Our Ref: SDNP/20/00261/ADJAUT
Contact Officer: Nat Belderson

23rd January 2020

Neighbouring Authority Consultation

**Proposal: Adjacent Authority Consultation - A/177/19/PL - New building for storage or distribution, light industrial & office (Class B1/B8) & associated parking. This application is a Departure from the Development Plan & may affect a Public Right of Way.
Address: The Vinery , Arundel Road , Poling , BN18 9PY**

drawing: Proposed Elevations Sheet 1

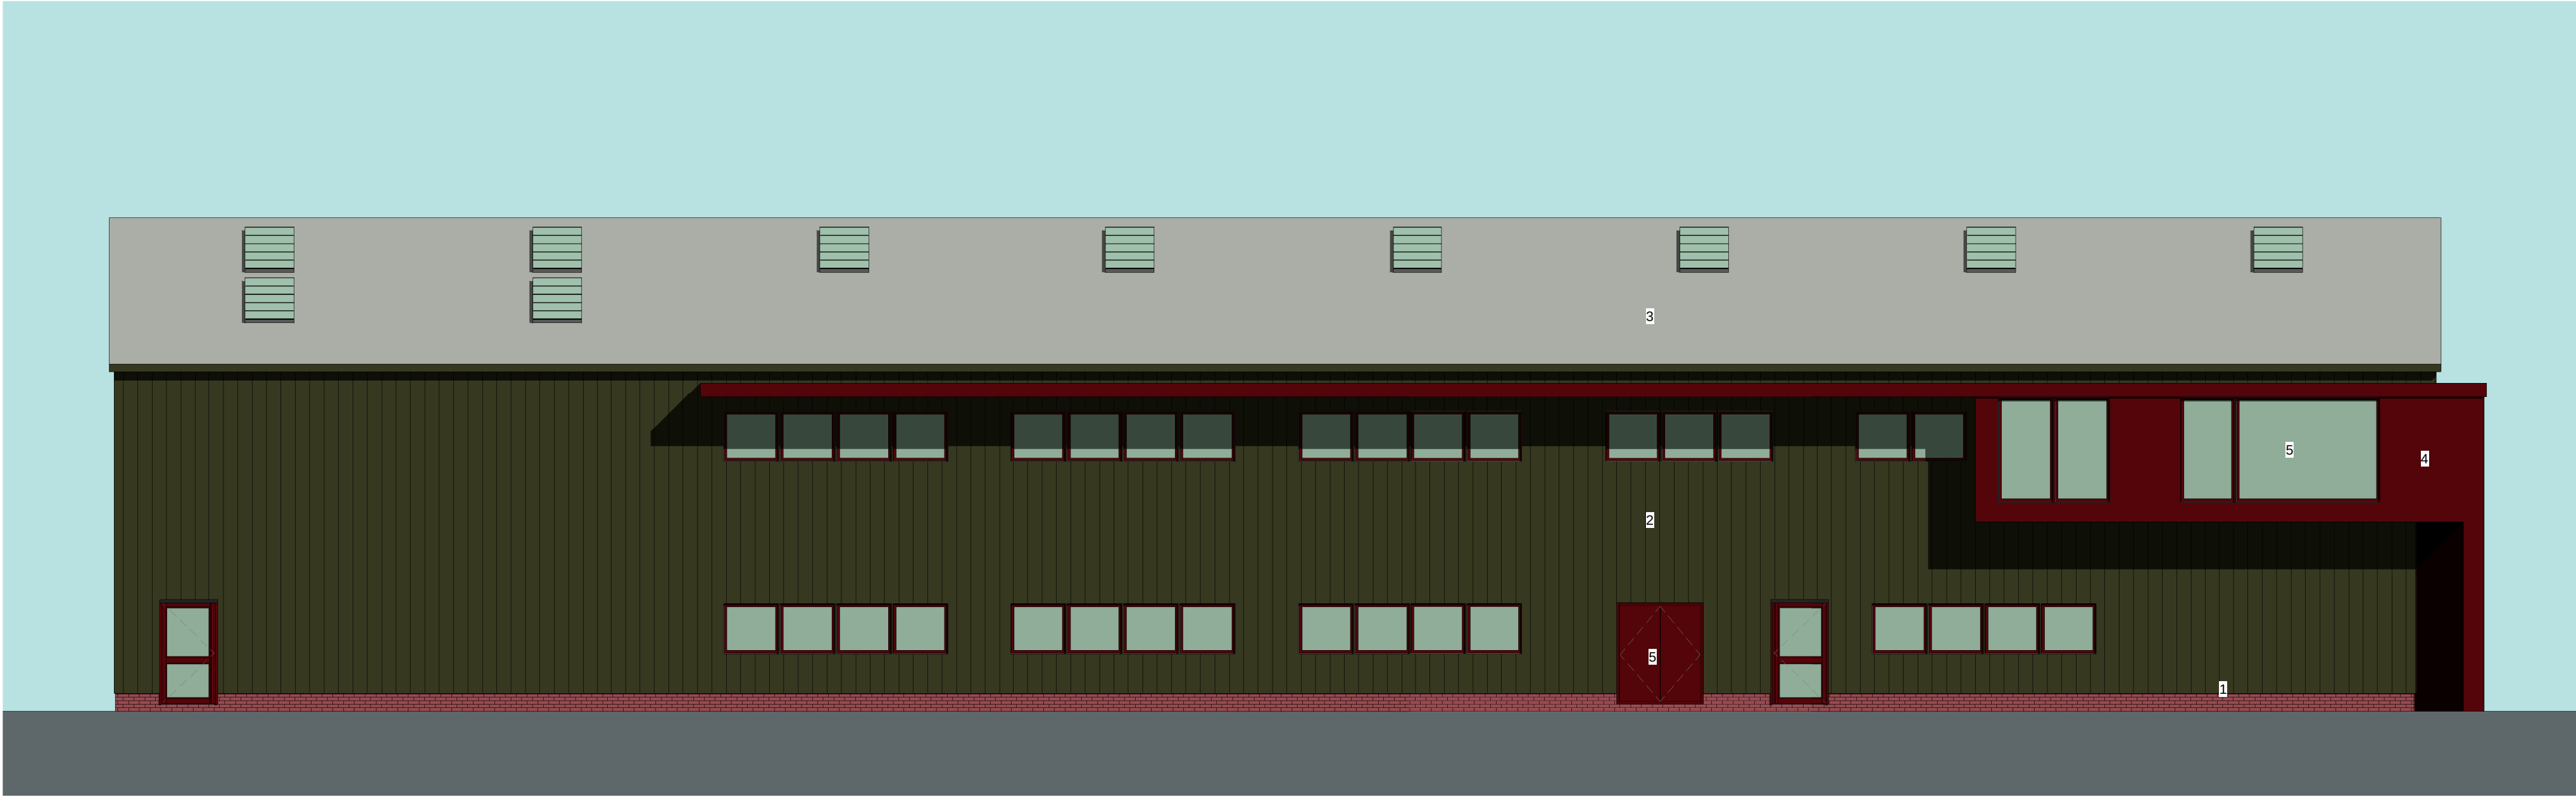
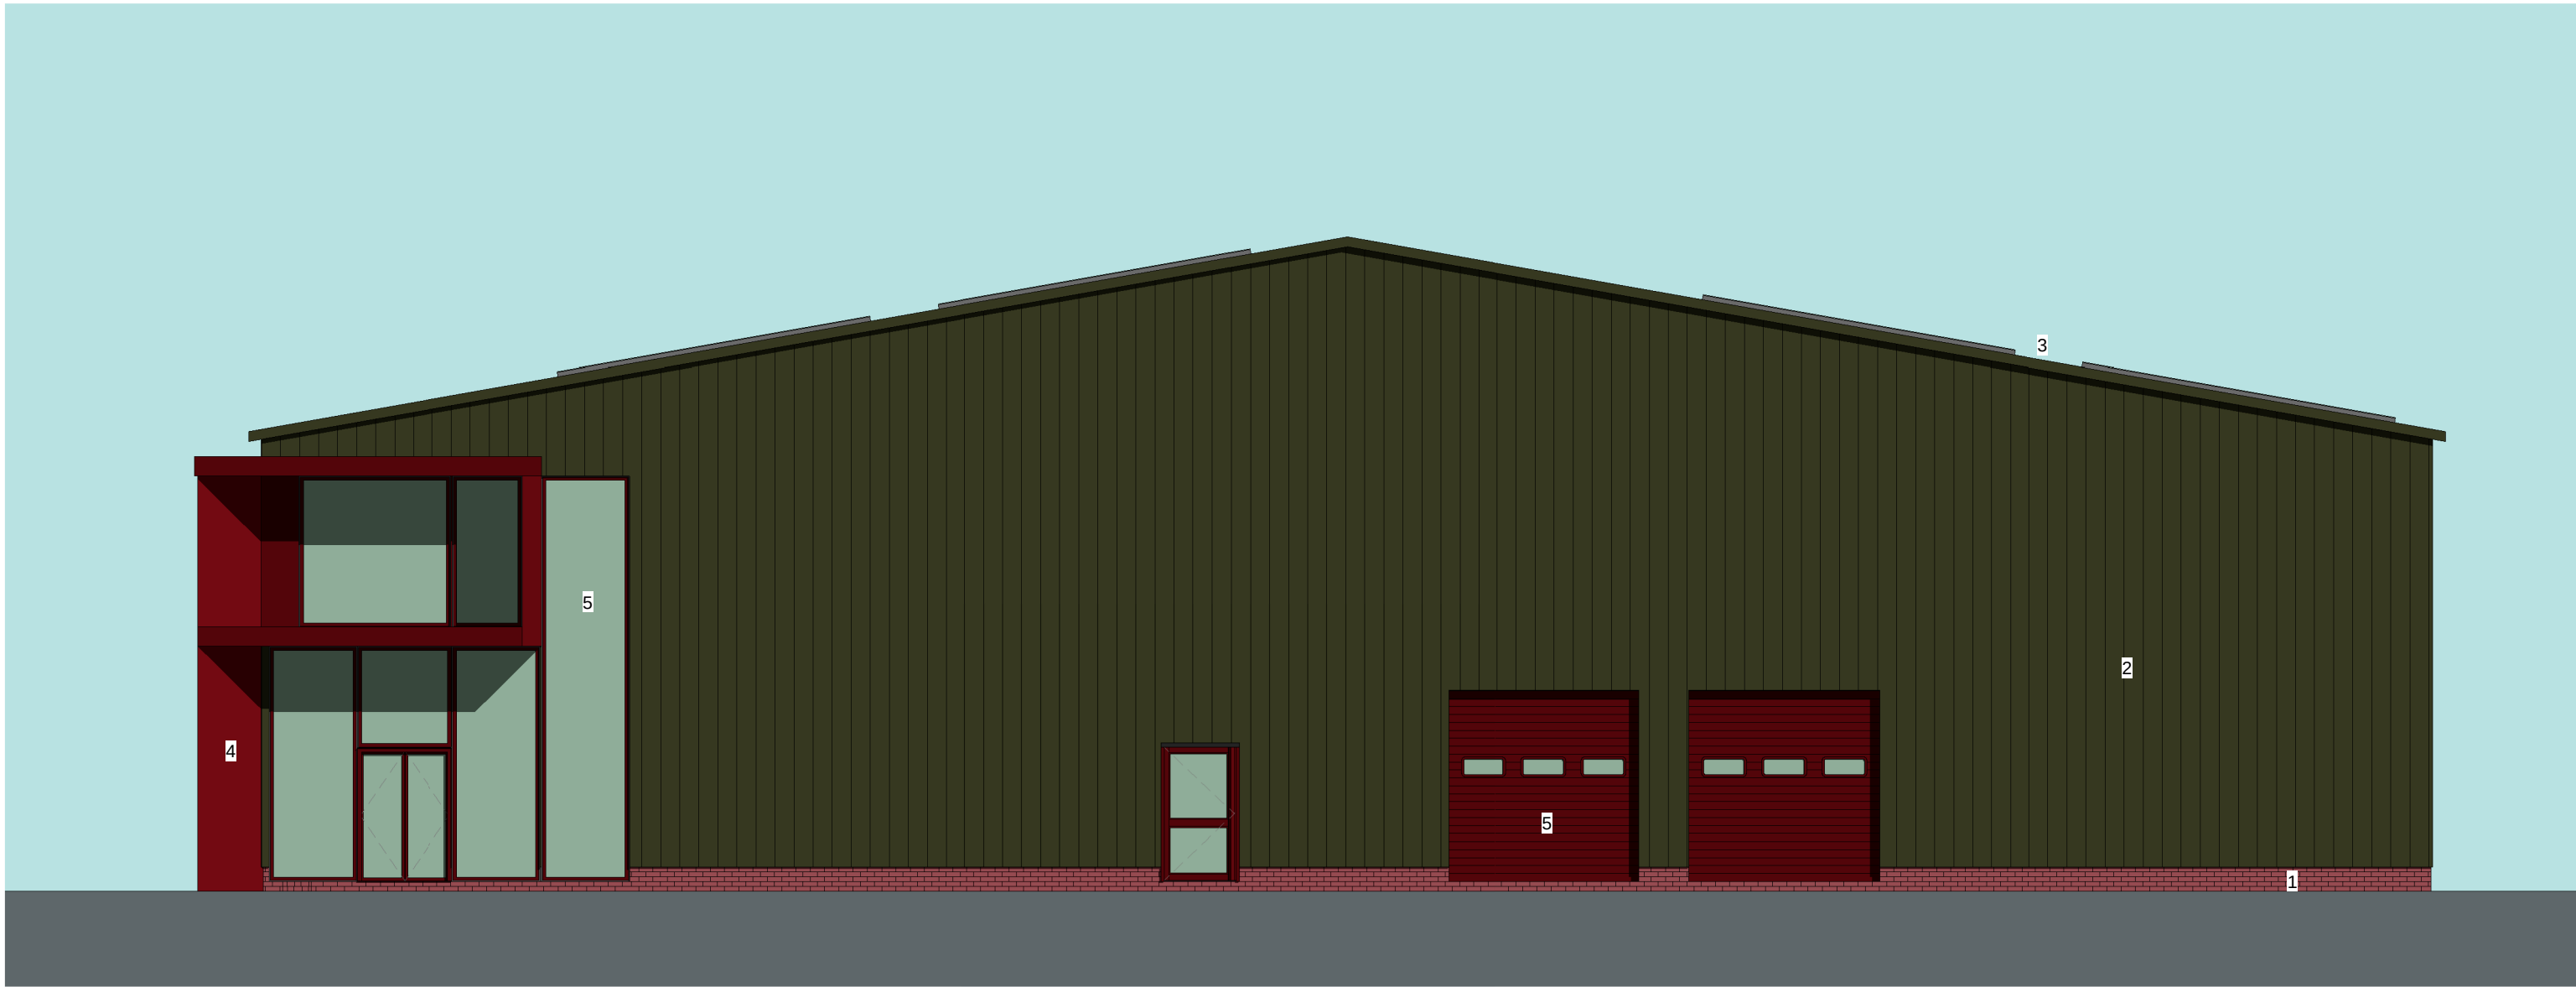
The application documentation states that there will be limited external lighting on the building in addition to roof lights which will provide natural daylight (but which would allow upward light spill at night). We are unclear as to what, if any, additional lighting would be required for parking areas associated with the proposals. A lighting scheme associated with the scheme should conform to the Institute of Lighting Professionals guide for lighting in environmental zones, and ideally try and achieve zero upward light in all respects, and we would welcome the delivery of the measures set out in sections 5.12 and 5.13 of the Ecological Assessment.
